Vickery Mine Extension (SSD-7480): Response to Submissions

I refer to the Department of Planning, Industry and Environment request dated 27 September 2019 inviting the Resources Regulator to review the Response to Submissions for the Vickery Mine Extension (SSD-7480).

The review of the *Vickery Extension Project Submissions Report* (Whitehaven Coal, August 2019) noted that with respect to the final landform, the proponent made the following commitments:

Figure 8: Conceptual Rehabilitation Plan

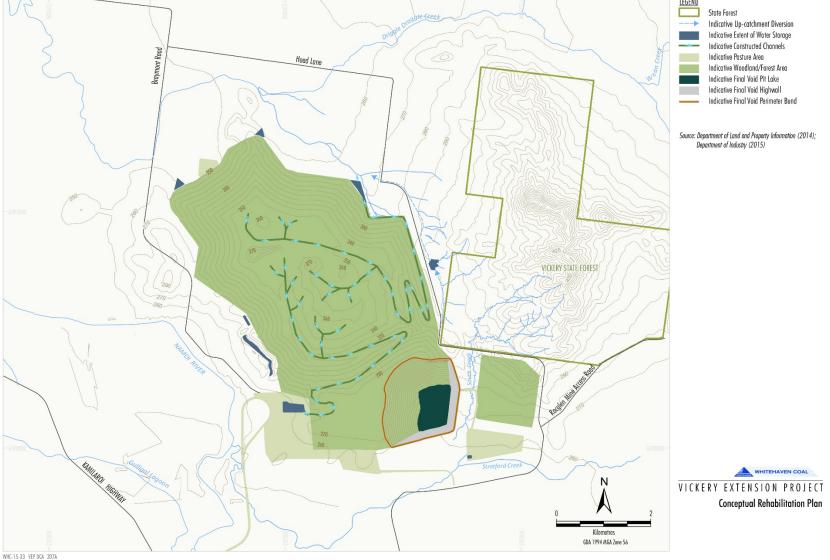
To maximise opportunities for micro-relief in the Project landform and to minimise the need for bench drains on the outer batters of the Western Emplacement, Whitehaven commits to landform review using GeoFluv™ software or similar during the life of the Project.

Whitehaven commits to establishing a waste rock emplacement that incorporates natural landform design features that reflect characteristics of the topography found in the adjacent Vickery State Forest (e.g. elevated landforms with steeper slopes in some areas relative to the surrounding plains).

The Regulator supports the intent of this commitment, however does not endorse specific methodologies to achieve this outcome. As such it should be noted that under the conditions of a mining lease granted under the *Mining Act 1992*, the Resources Regulator, requires a mining lease holder (holder) to adopt a risk-based approach to achieving the required rehabilitation outcomes. The applicability of the controls to achieve effective and sustainable rehabilitation is to be determined based on the site specific risk assessments conducted by a holder.

The Resources Regulator requests a review of the draft development consent conditions prior to finalisation and any granting of development consent to ensure that rehabilitation obligations are clear and enforceable, particularly in relation to achieving landforms that are sustainable and commensurate with surrounding areas.
